April 6, 2015

**RE: Response to City Staff Review Comments
Final Site Plan Application
Hotel Redevelopment
1210 Brighton Avenue
Portland, Maine**

Sheet Title:
PHOTOMETRIC PLAN

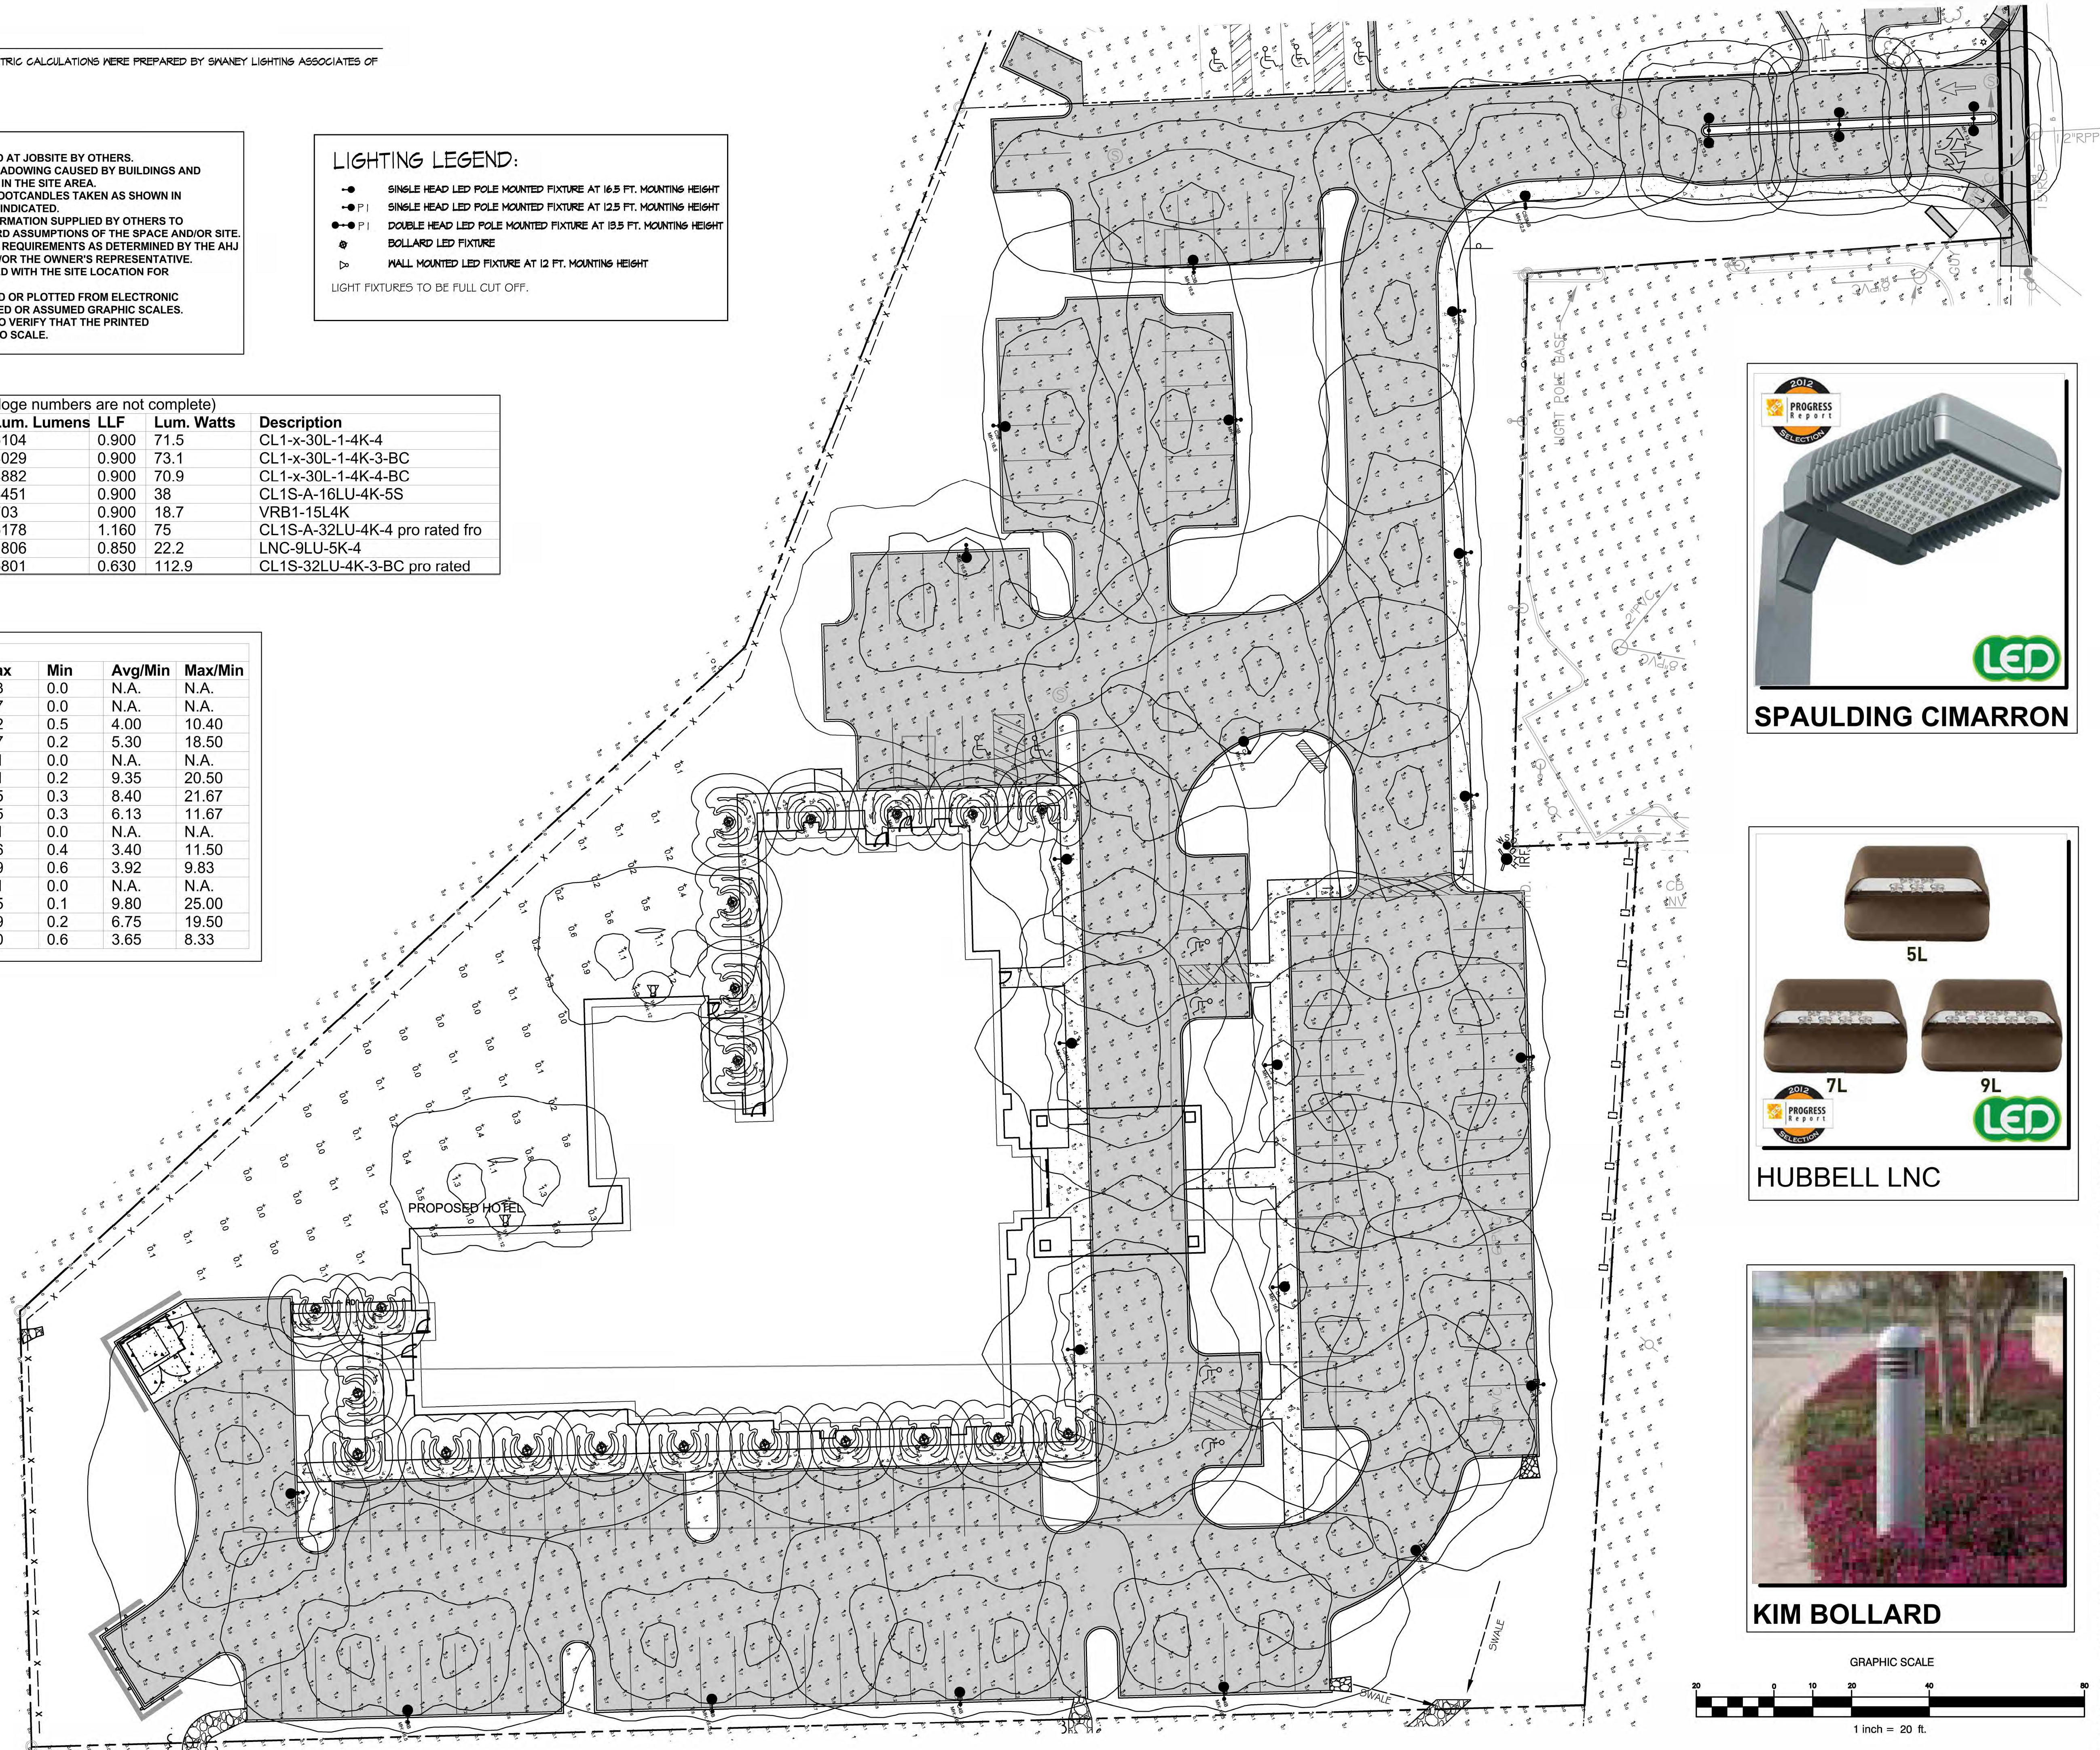
1. Can you provide a calculation for the average illumination level across the whole site? The Technical Manual specifies that averages need to be below 1.25 foot candles.

2. There are a couple of spots where the illumination levels exceed our maximum of 5 fc. Can you bring these numbers down in these locations at all?

3. The bollards do not appear to be full cutoff, although you note otherwise. Can you provide a cut sheet that clarifies this?

A calculation grid was added to cover the entire site. An average of 1.0 fc was achieved. The minimum, maximum, and average levels are provided on the bottom row of the calculation summary table on the plan.

The lumen output of the three pole-mounted light fixtures at the drop-off area drive in front of the building was lowered. Some of the bollards were revised to a symmetrical distribution type and locations were slightly adjusted. These modifications reduce all points to less than 5 fc.

A cut sheet for the bollard light fixture is enclosed. The VRB1 model will be used, which is full cut-off above 90°.
